March 22, 2019

**RE: Mister Car Wash - 98th St. & Volcano Rd.
Grading and Drainage Plan & Drainage Report
Engineer's Stamp Date: 03/14/19
Hydrology File: K08D004**

Based upon the information provided in your submittal received 03/14/2019, the Grading & Drainage Plan and Drainage Report **is not** approved for Building Permit, Grading Permit, Work Order, and for action by the DRB on Platting and Site Plan for Building Permit. The following comments need to be addressed for approval of the above referenced project:

<p>RONALD R. BOHANNAN P.E. #7868</p>	MISTER CAR WASH 98TH ST & VOLCANO RD GRADING AND DRAINAGE PLAN	DRAWN BY DY DATE 3/27/19 2018058-GR-20
	 TIERRA WEST, LLC 5571 MIDWAY PARK PLACE NE ALBUQUERQUE, NM 87109 (505) 858-3100 www.tierrawestllc.com	SHEET # C2 JOB # 2018058

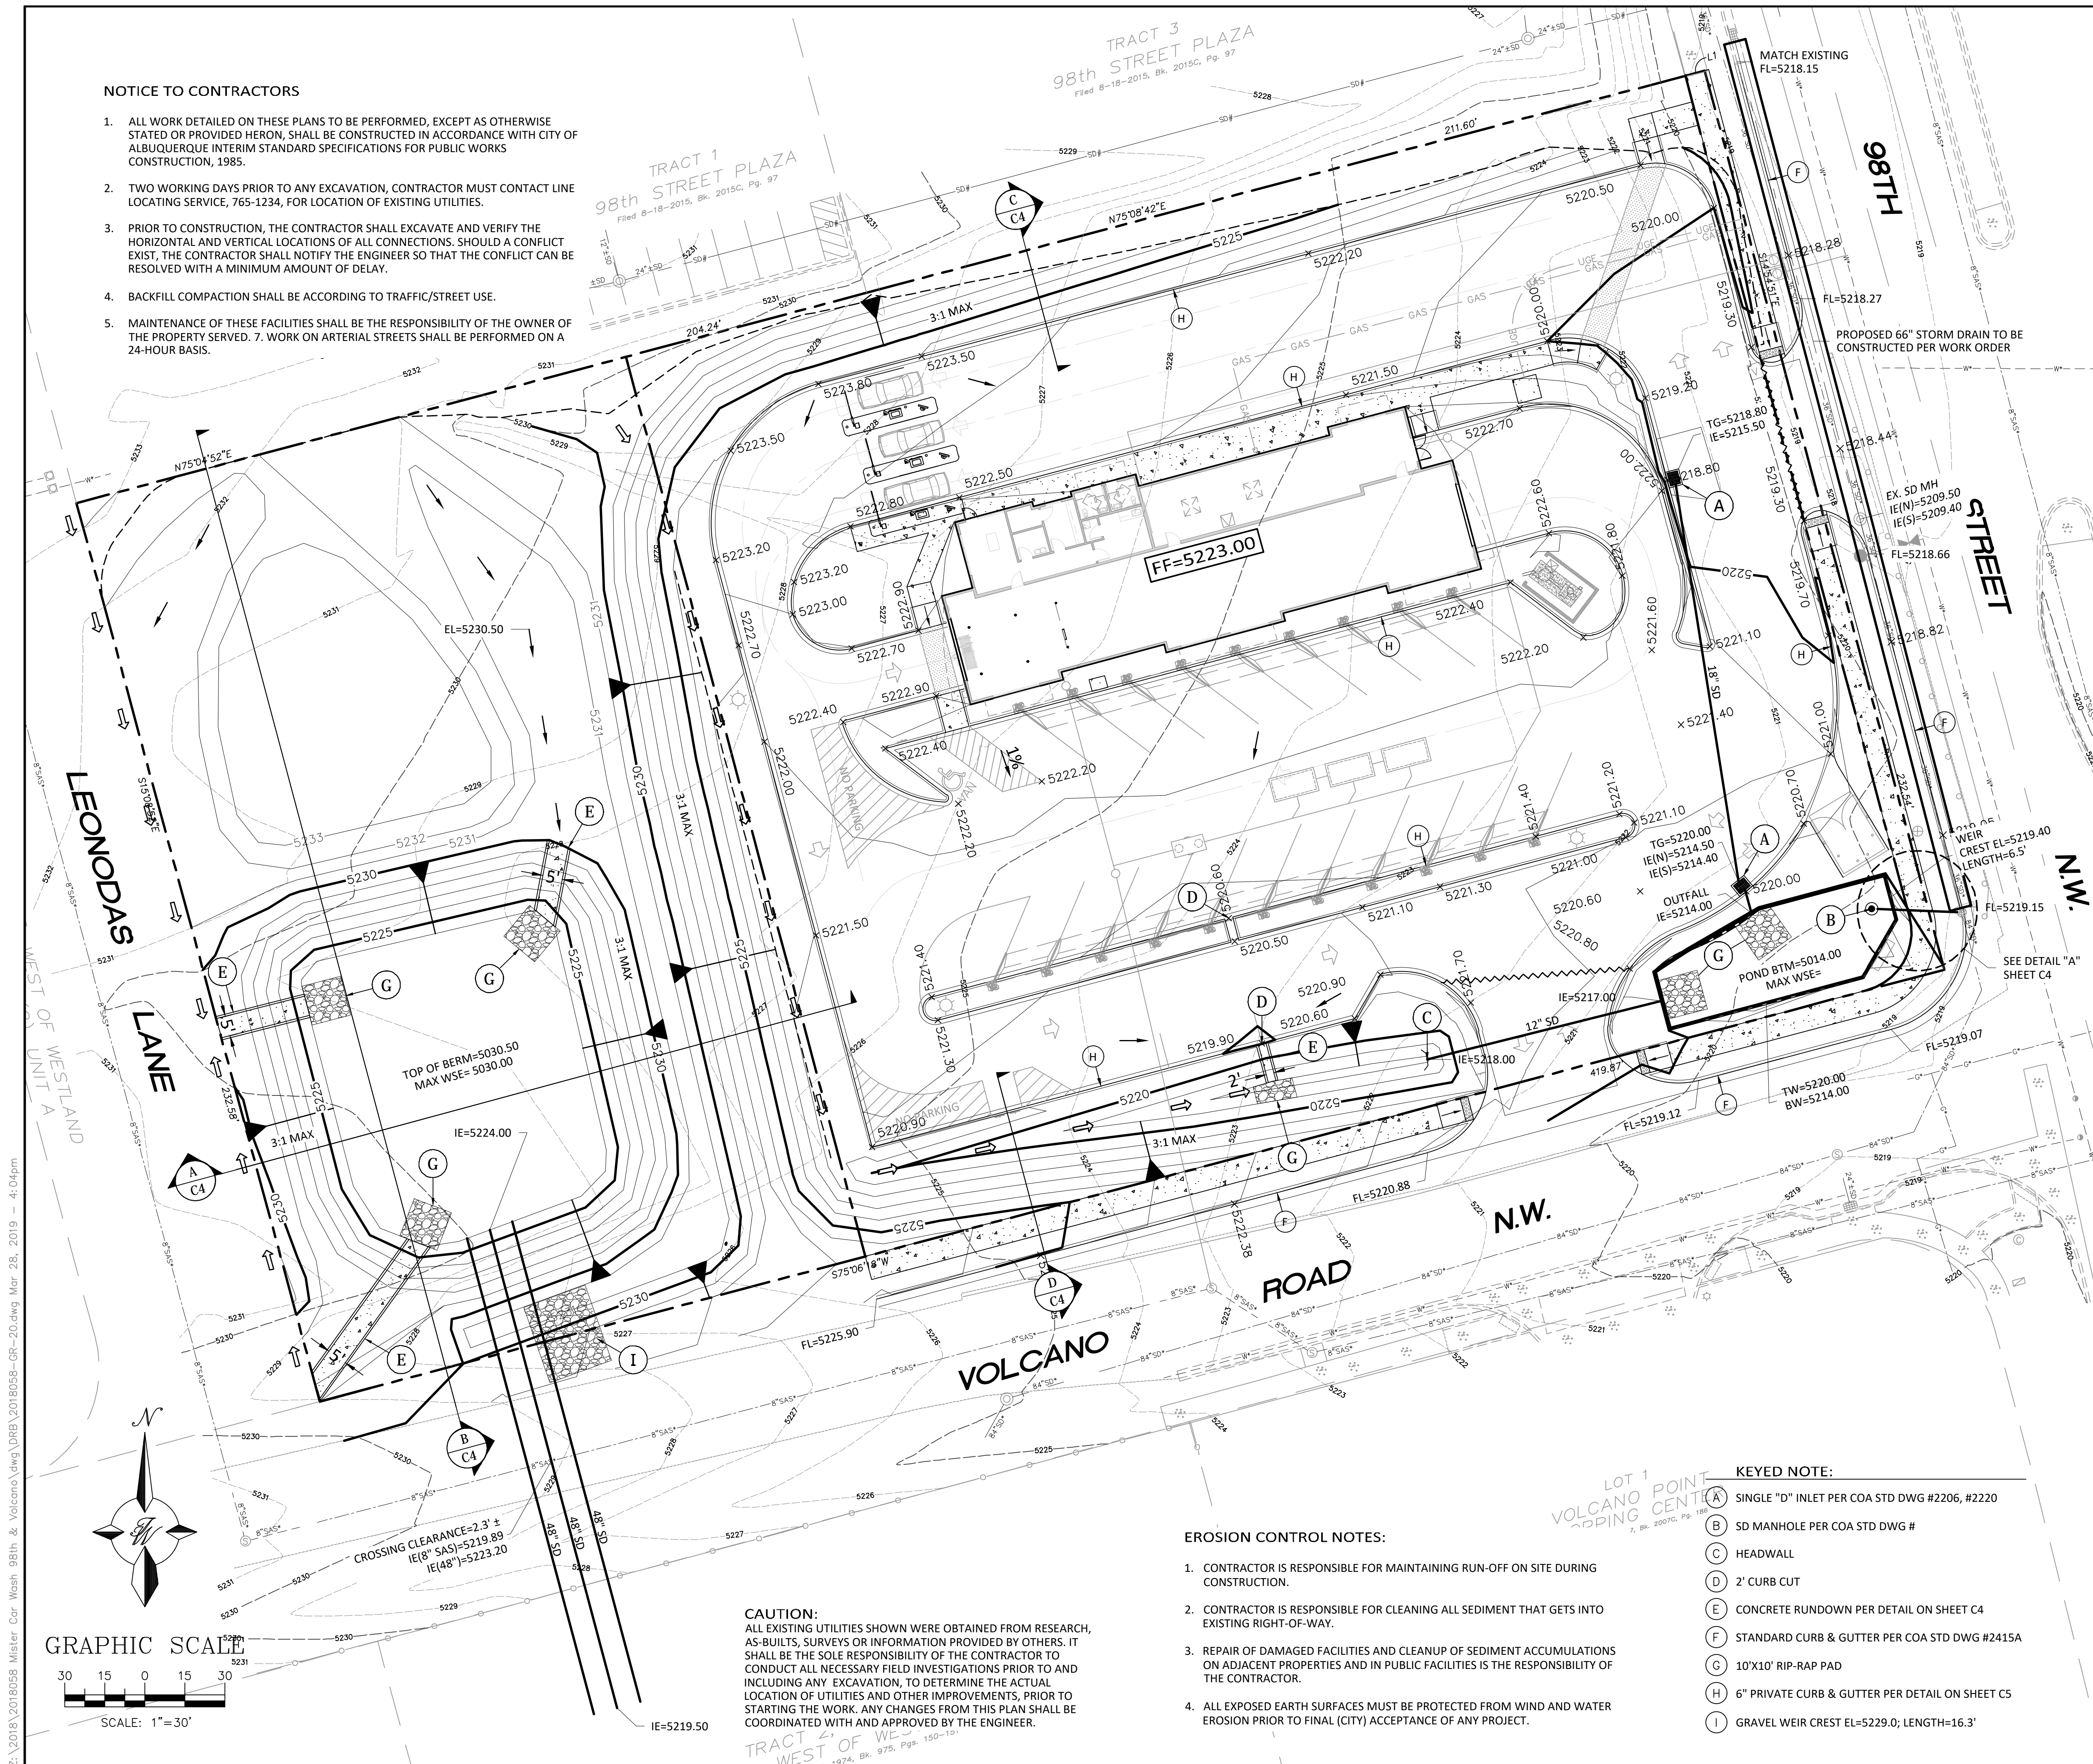
7. Sheet C2. Please either show a swale or revise grades to direct the flows from the off-site basin to Leonodas Lane.
8. Sheet C2. Please show the proposed 66 inch storm pipe along 98th St. and add a label stating. "To be constructed with work order."

9. Sheet C2. Please add the flowline elevations along the prop curb on both 98th St. & Volcano Rd.
10. Sheet C2. Please enlarge the area of the stormwater quality pond and remove the proposed contours so that the proposed retaining wall will be shown.

11. Sheet C2. Please add the top of pond and bottom of pond for the City's detention pond.
12. Sheet C4. Please add a section showing the 48 inch culverts, temporary pond, Volcano Rd curb & sidewalk, the existing City Pond, and the existing 8" sanitary sewer. Also add the clearance for the sanitary sewer and the top of storm pipe.

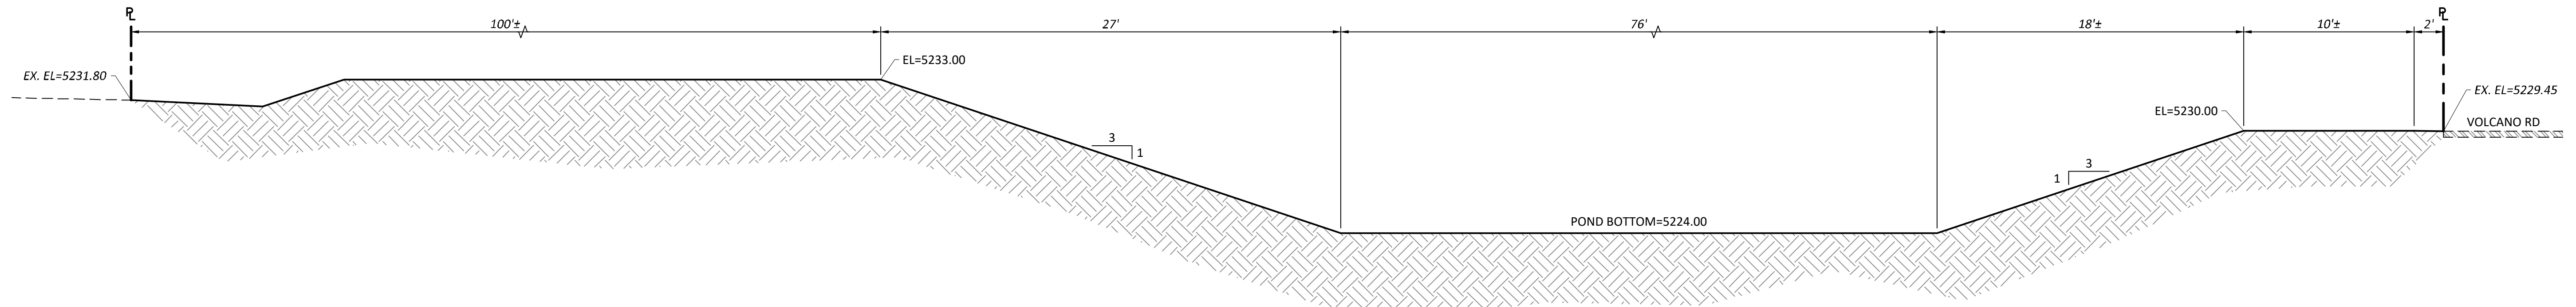
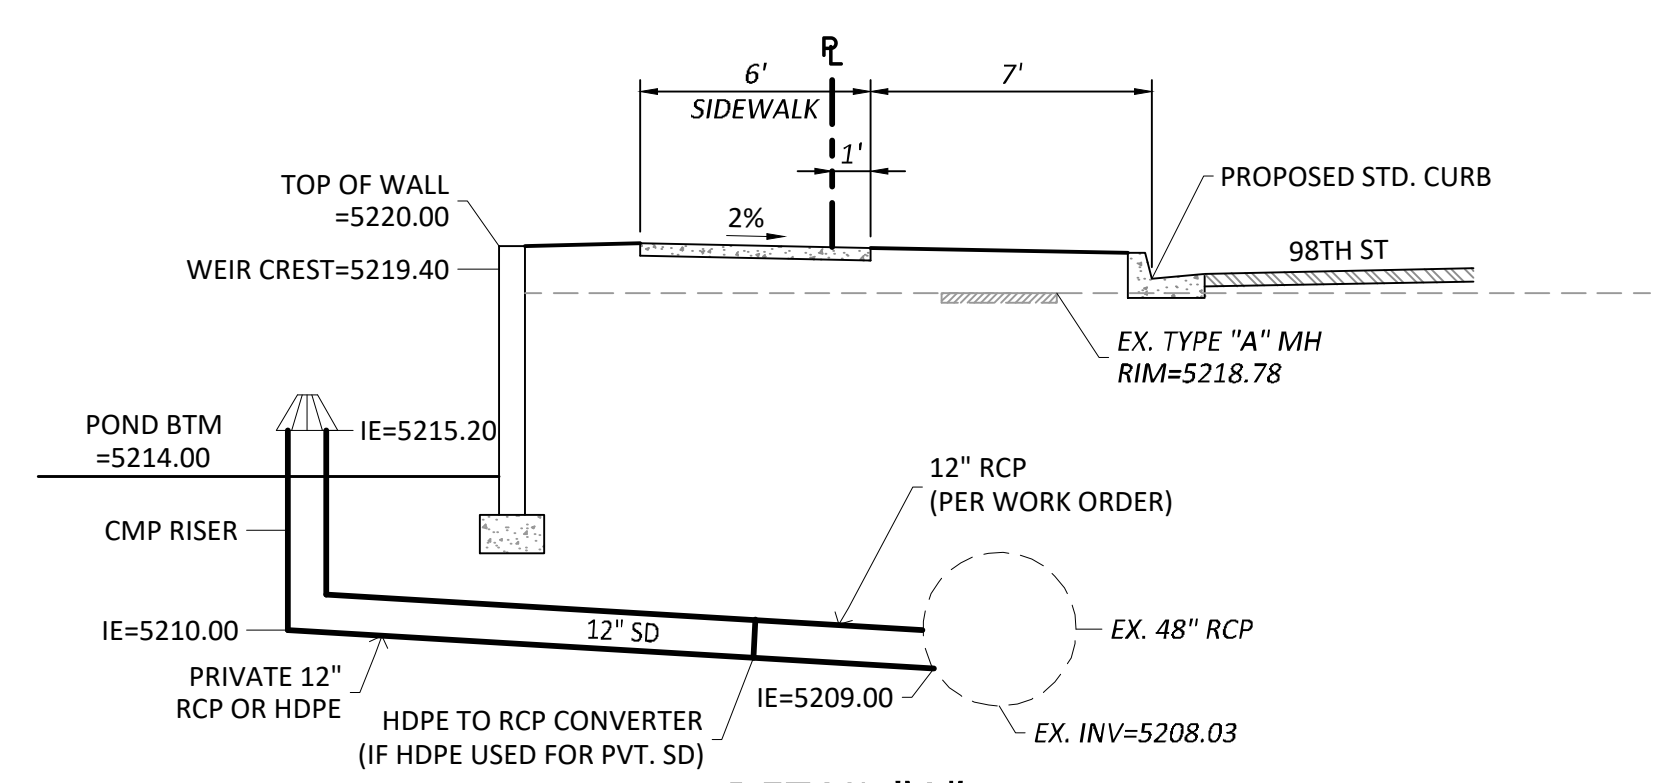
13. Sheet C4 - Detail "A". Either change the pipe from HDPE to RCP or add a converter from HDPE to RCP at the R.O.W. and add the detail from ADS.
14. Please remove Sheets C3 and C5 from further submittals to Hydrology. These are not needed.
